**WELWYN HATFIELD BOROUGH COUNCIL
EXECUTIVE DIRECTOR - PLANNING, PUBLIC PROTECTION AND GOVERNANCE**

DELEGATED APPLICATION

Application No: 6/2021/0250/VAR
Location: Stanborough School Lemsford Lane Welwyn Garden City AL8 6YR
Proposal: Variation of condition 3 (approved drawings) on planning permission 6/2019/2587/VAR
Officer: Mr Raymond Lee

6/2021/0250/VAR

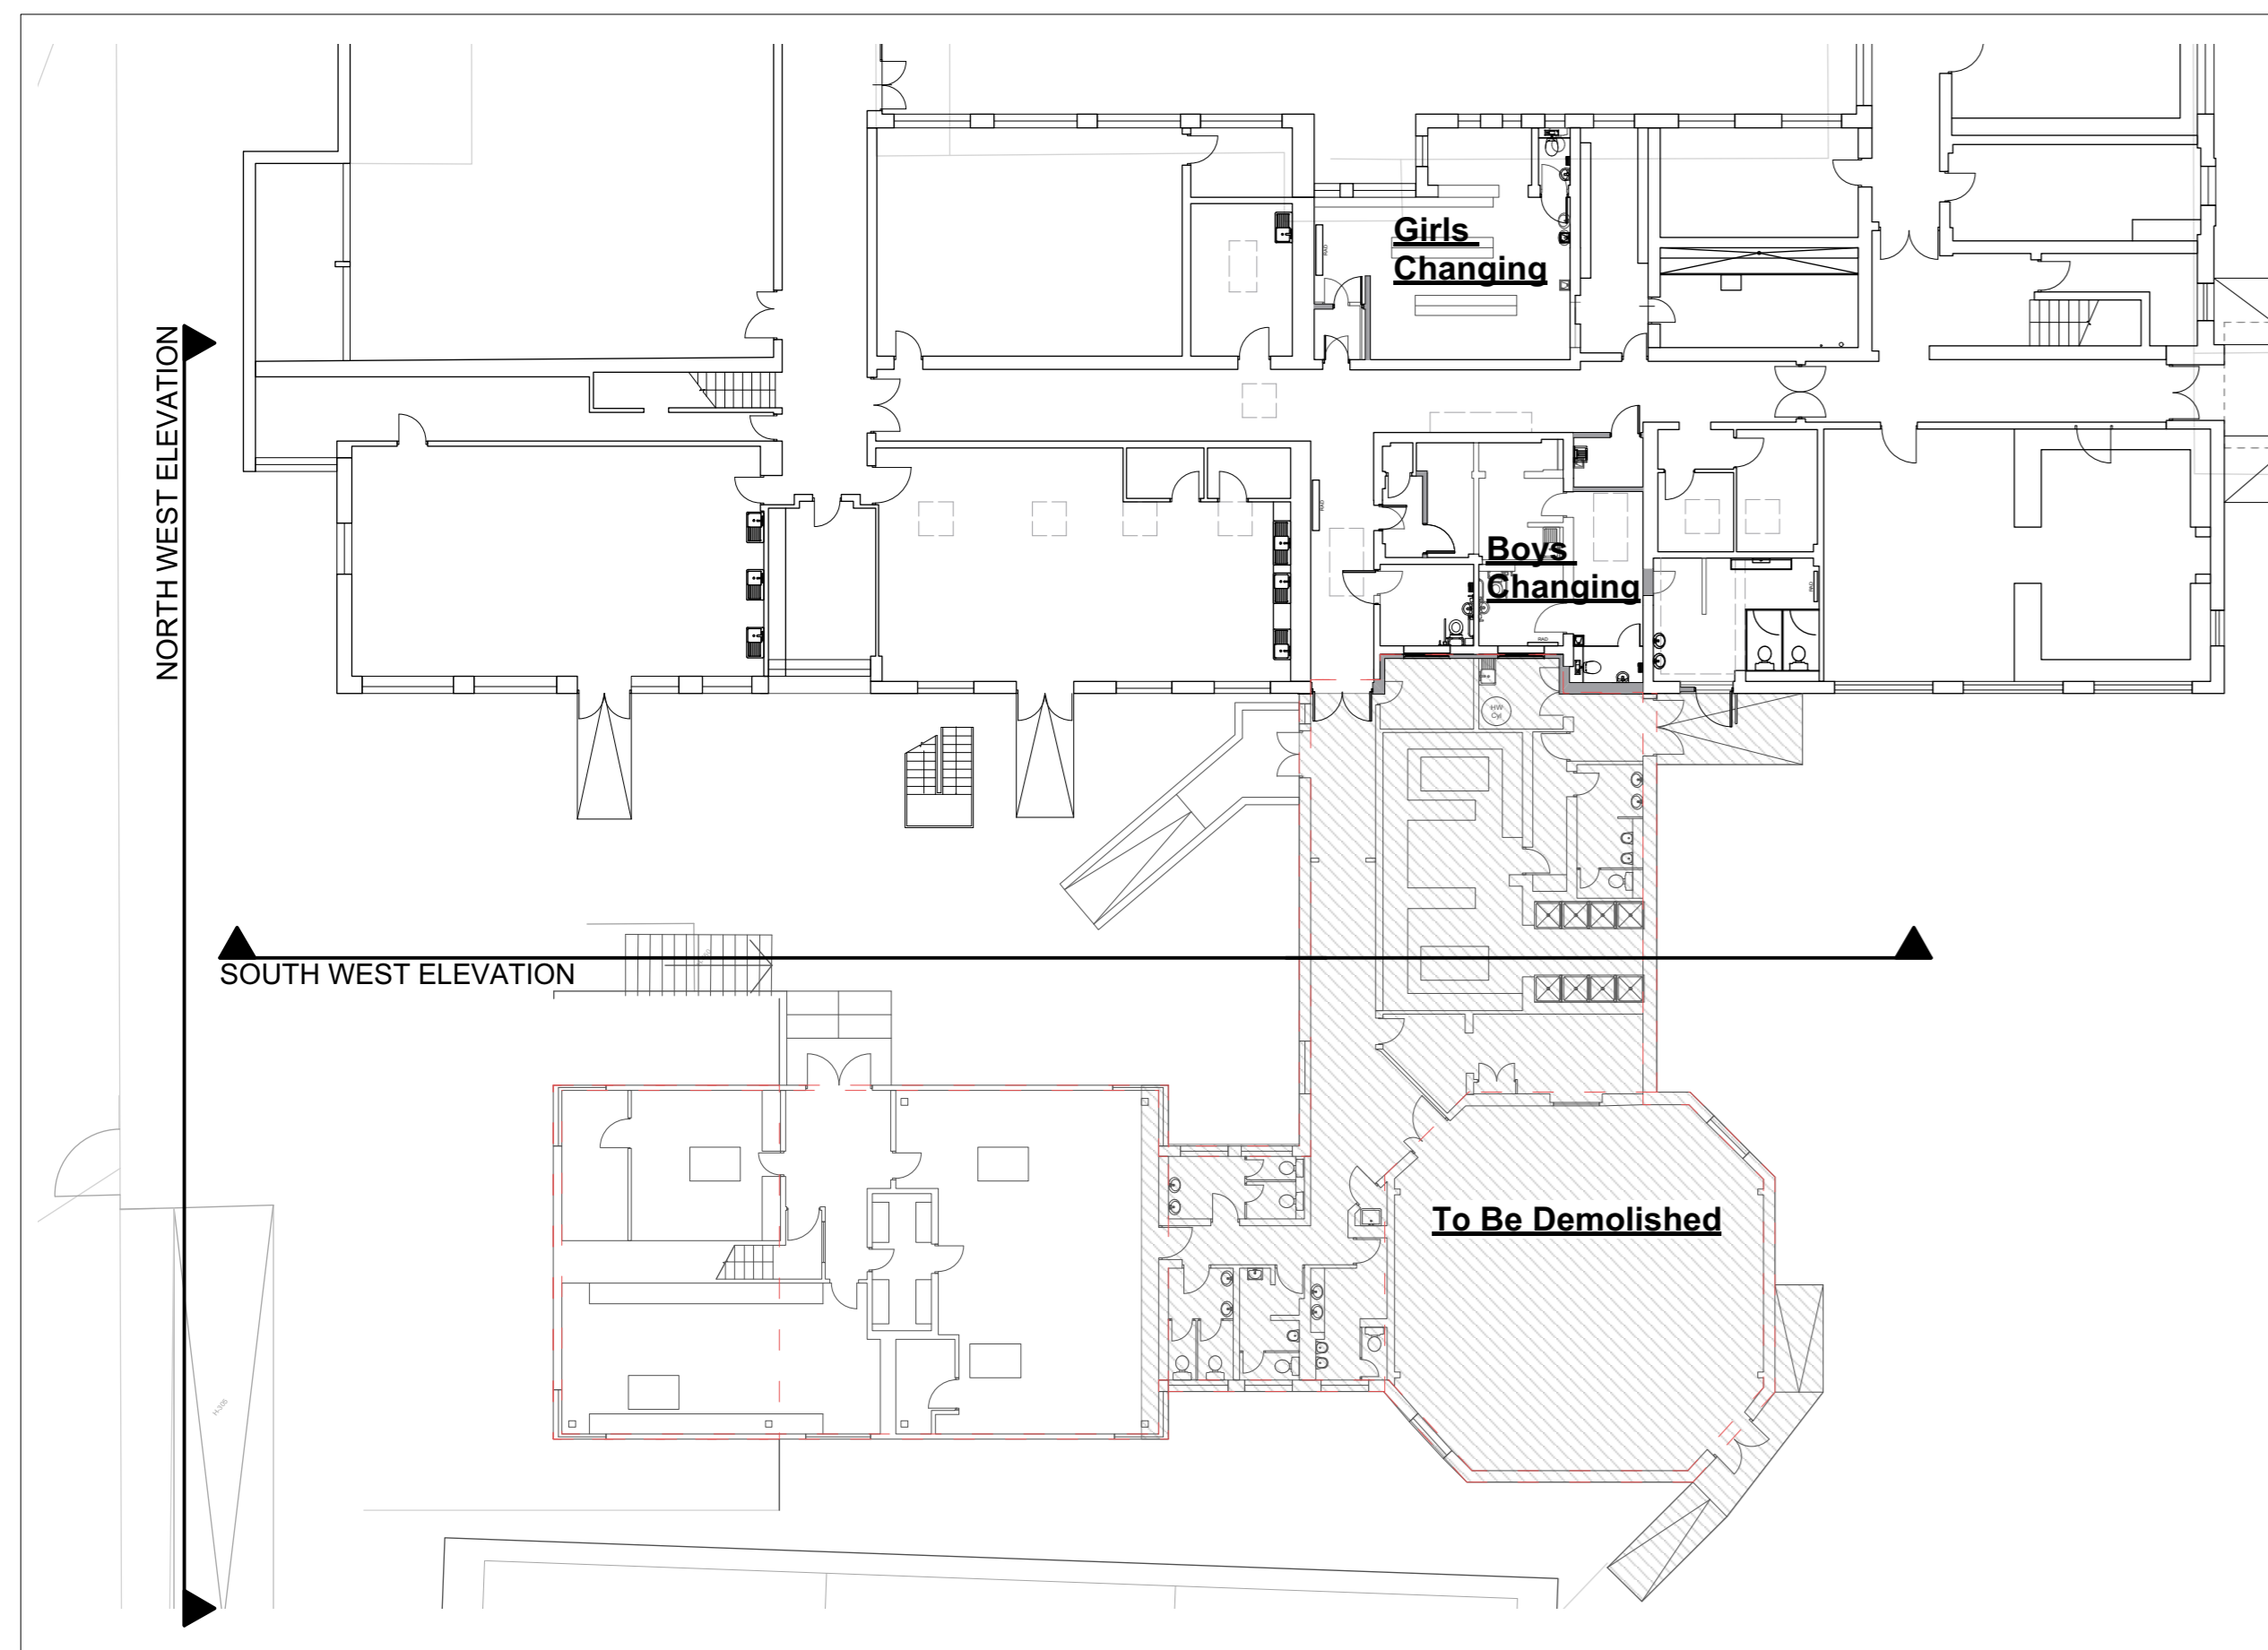
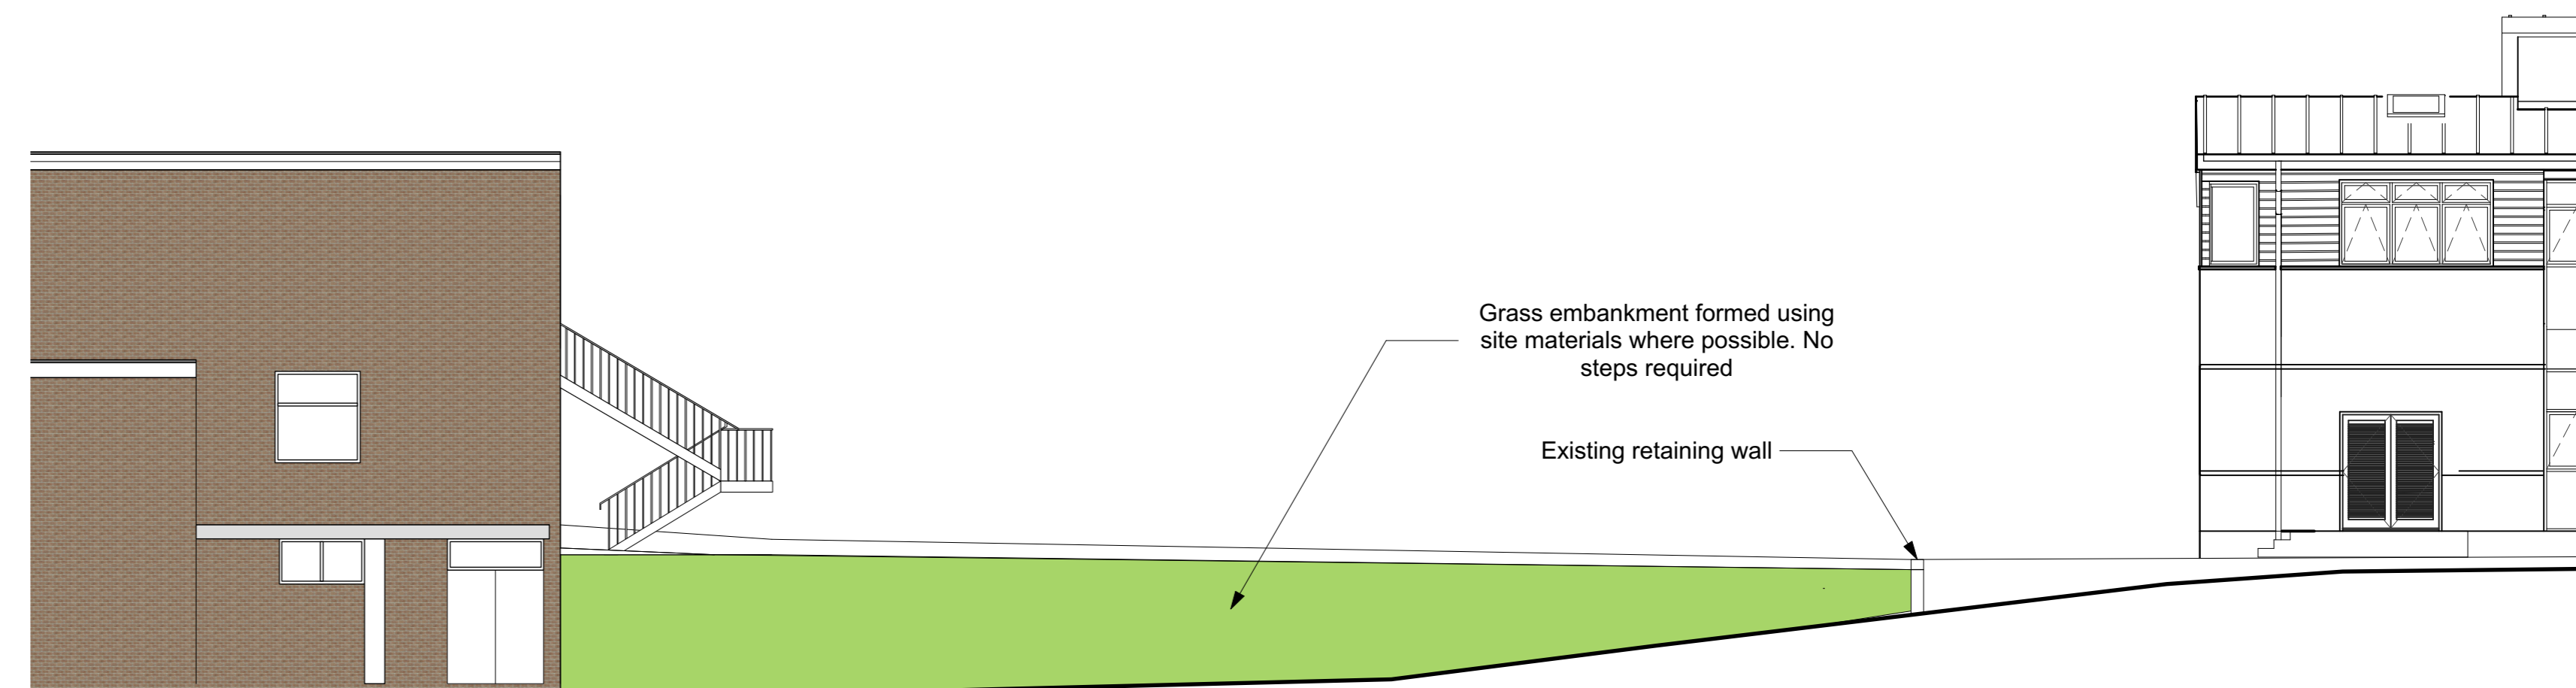
Also proposed are changes to the fenestration of the main building following the demolition of the old Music and Drama block, to include two new sets of doors that will be accessed from the new tarmac area. This part of the scheme is considered modest and would not significantly alter the character of the school building on the wider site and setting.
